LIST OF CHANGES PROPOSED TO THE ALBUQUERQUE RV STORAGE PROJECT

Included are a list of changes proposed for the Albuquerque RV Storage project #PR-2020-004757 that is conditionally approved with the City. This is in an effort to meet compliance with Waste Managements requested location of the Trash Enclosure, and DRC public infrastructure design requests. Additional minor site improvements have also been made for overall design improvements.

RV STORAGE - ALBUQUERQUE
ALBUQUERQUE, NEW MEXICO
SITE PLAN
SITE PLAN

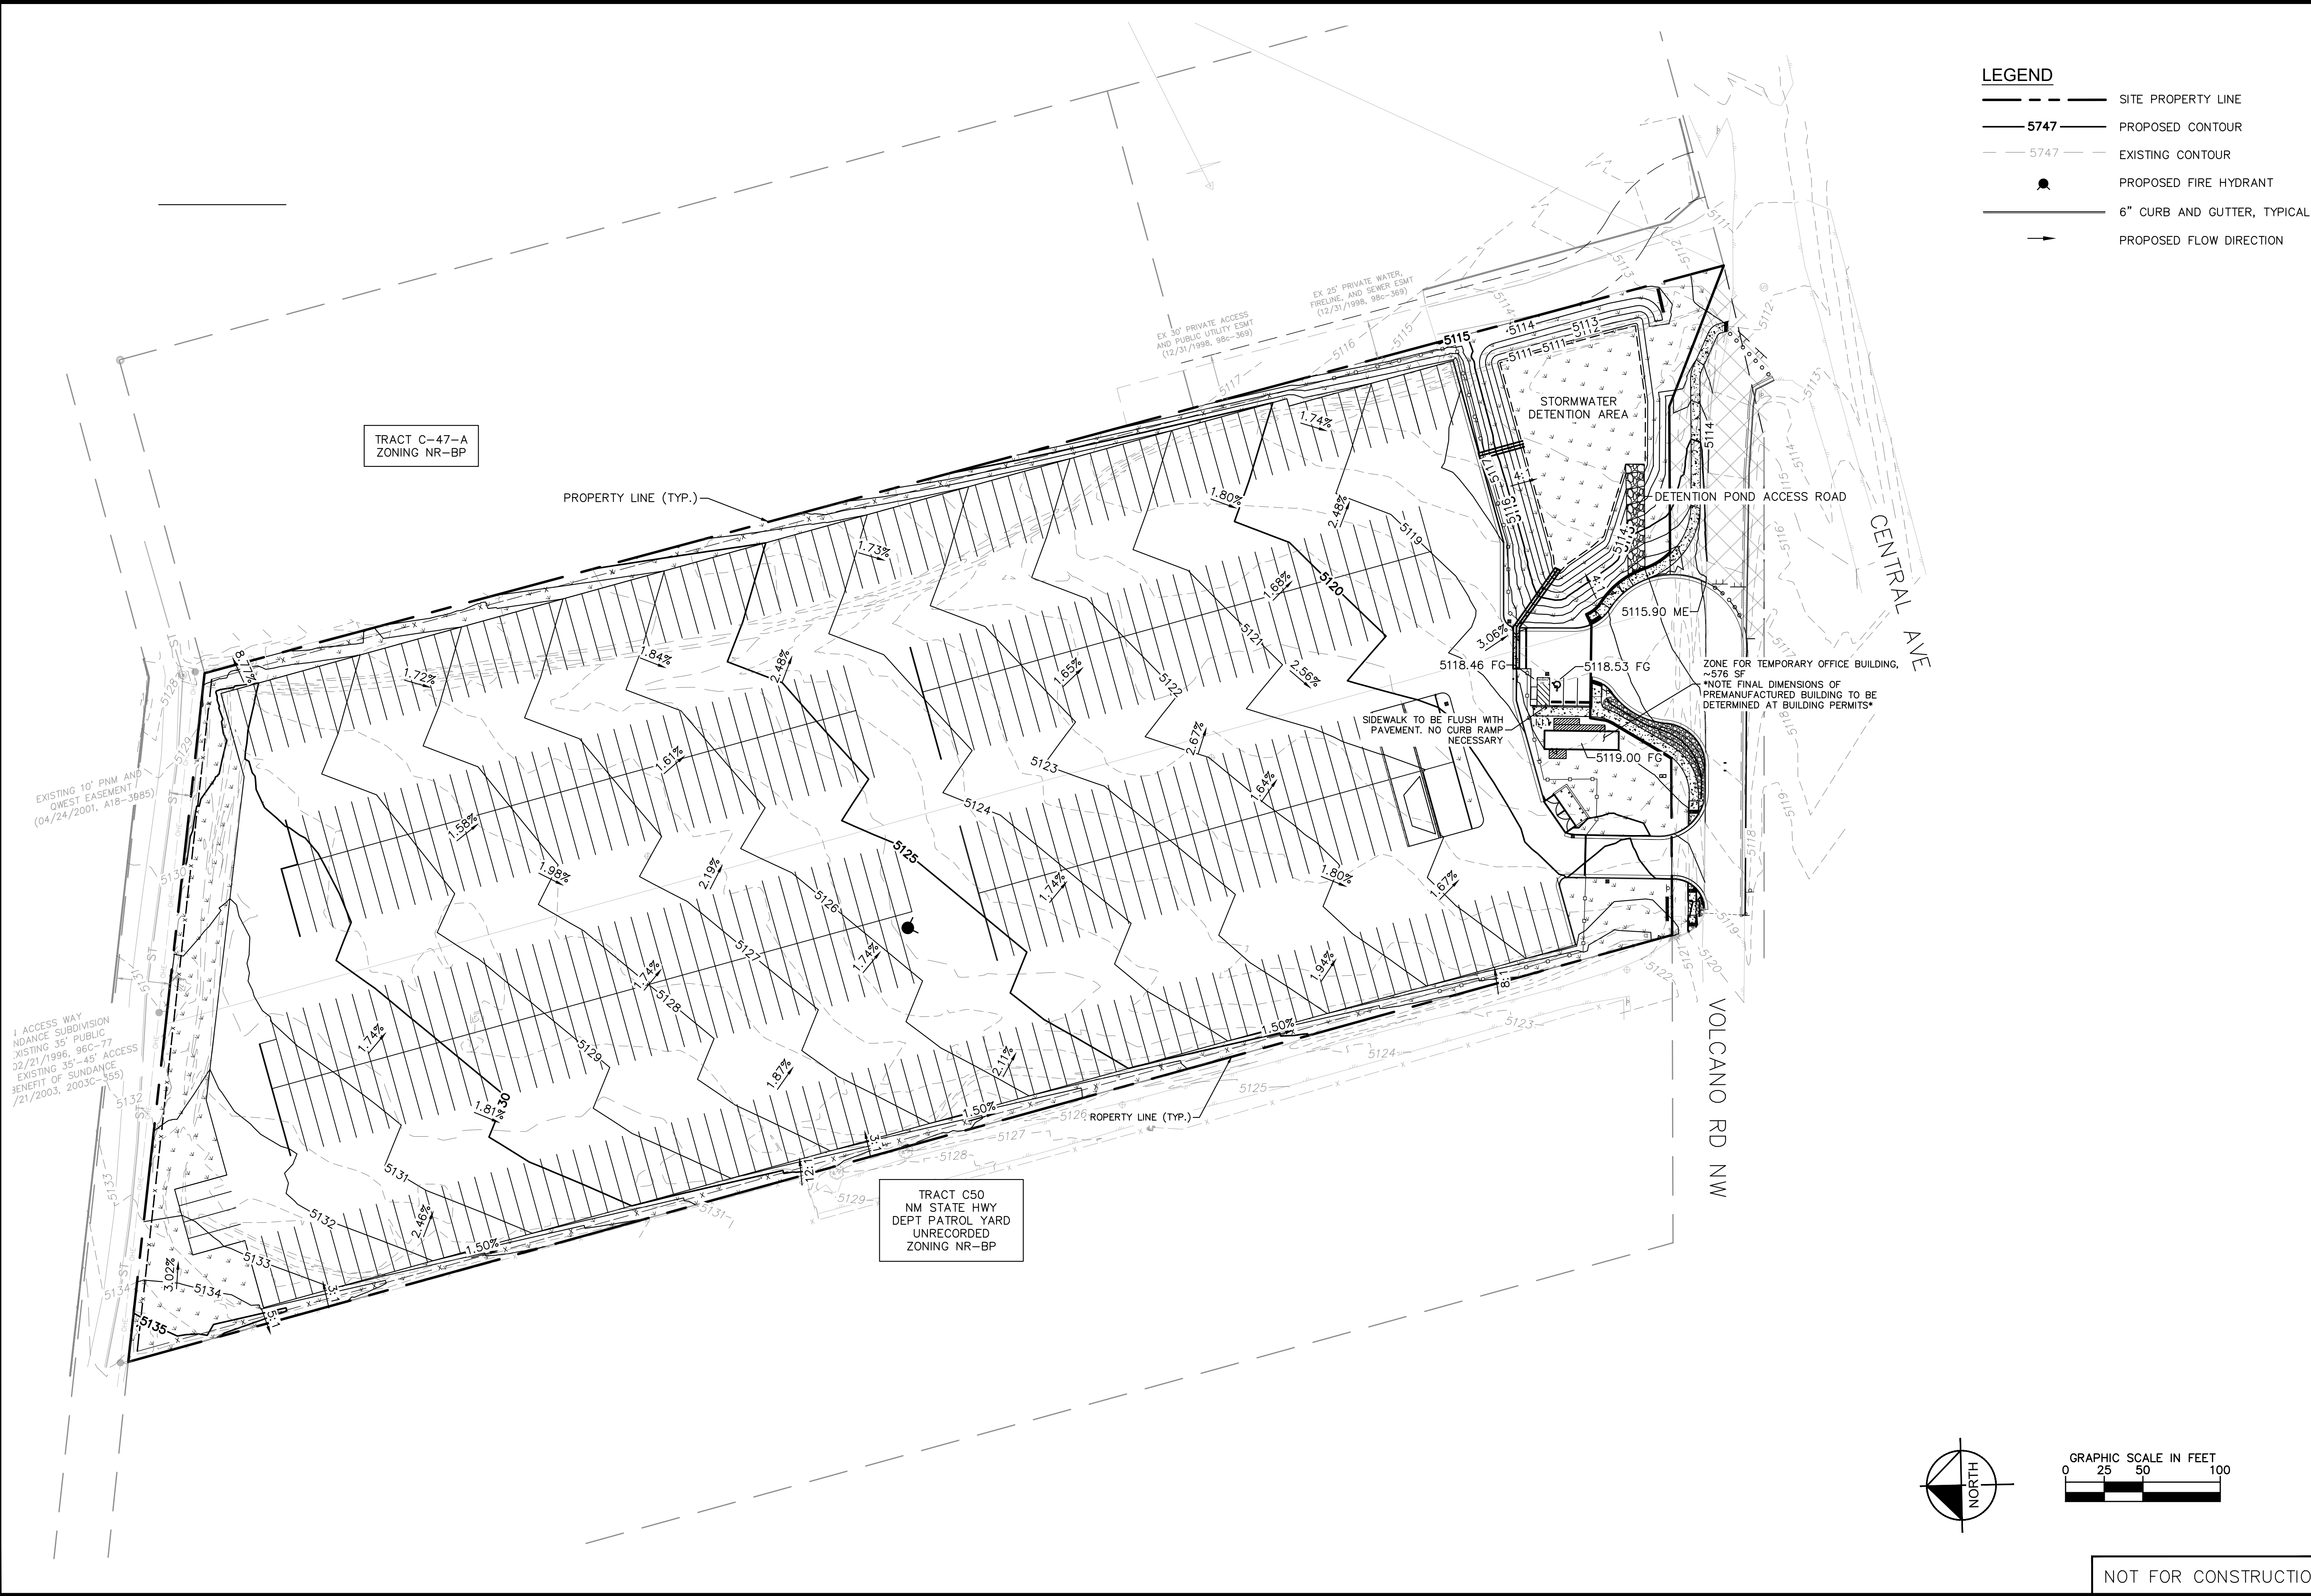
1. Layout to more accurately reflect the proposed building. Note that the official dimensions will be provided at Building Permit.
2. Relocation of the trash enclosure and update dimensions to meet Waste Management’s requirements.
3. Relocated internal RV Storage stalls within the interior of the site
4. Revised the water and sewer public main and private service lines per DRC request
5. Added additional curb and concrete valley gutter at the site entrance to aid in stormwater
